Application for a Non-Material Amendment Following a Grant of Planning Permission

Erection of two-storey side and rear extension. New gable roof following removal of existing flat roof. Erection of storm porch.

2023/0119

Minor changes to west elevation:

Site: Hill Farm Cottage Rectory Road NR35 2BT	Title: Proposed Floor Plans			
Job No: 7.178	Drg No: PRE-05A		Scale: 1:100@A2	Drawn By: MS

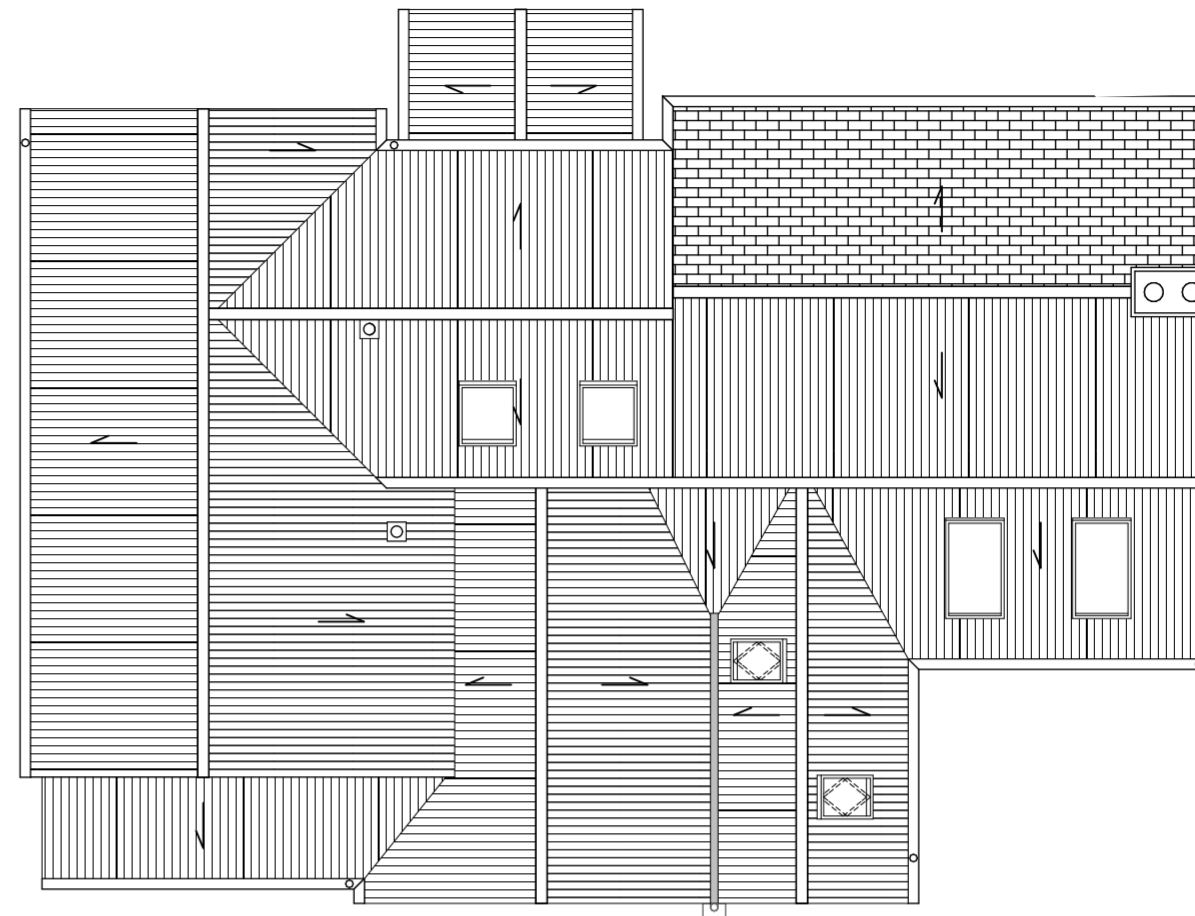
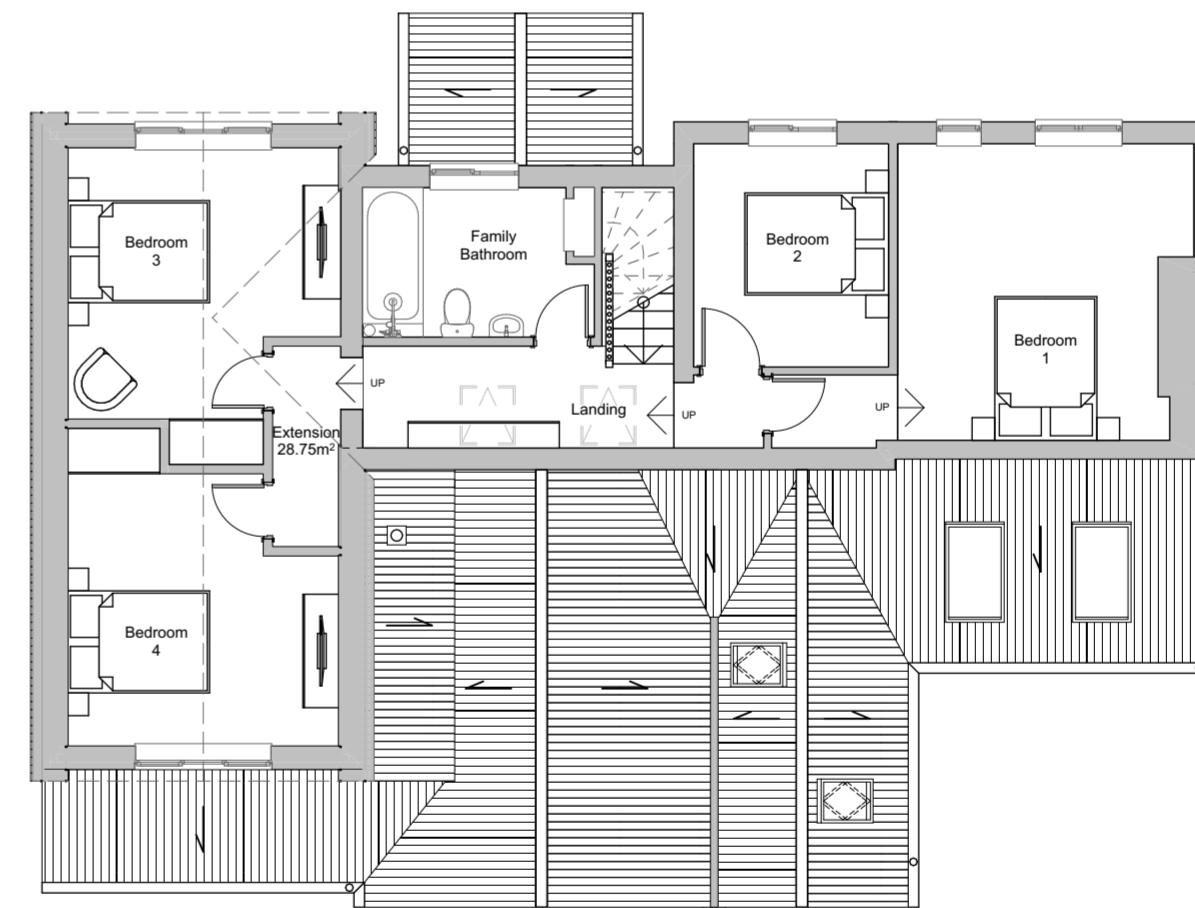
1. Retain existing bi-fold doors.
2. Substitute proposed bi-fold doors for window same width and head height as approved.

Proposed kitchen is to be repositioned/reconfigured.
